Modification of Minister's Approval

MP 05_0147 MOD 8 comprising amendments to the subdivision layout as follows:

PLAN OF PROPOSED SUBDIVISION OF THE INTERMODAL LOGISTICS CENTRE COSGROVE ROAD, ENFIELD

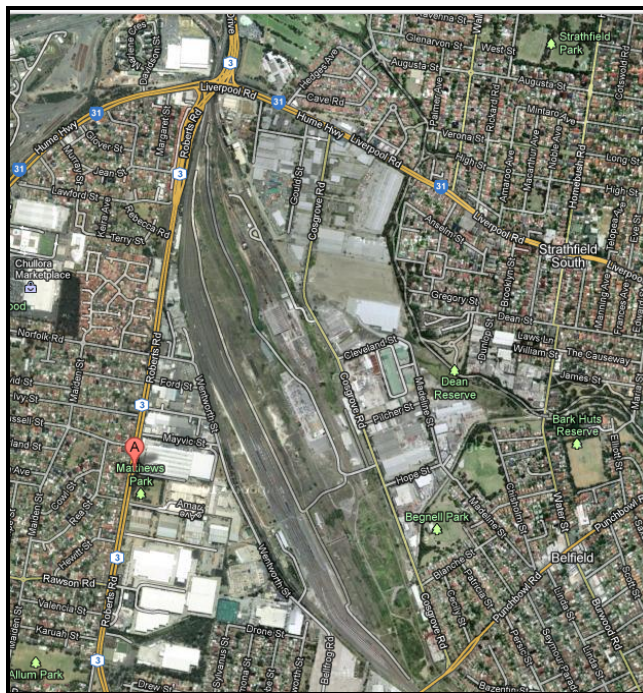
- merging Lots 5 and 6 into a single lot;
- subdivision of a portion of Lot 11 to provide two allotments (Lots 5 and 23);
- reducing those parts of Lot 22 that adjoin Lots 6, 8 and 11; and
- reallocation of the area under the bridge within the intermodal terminal from Lot 12 to Lot 11.

5. Replacing Appendix 1 with the following plan:
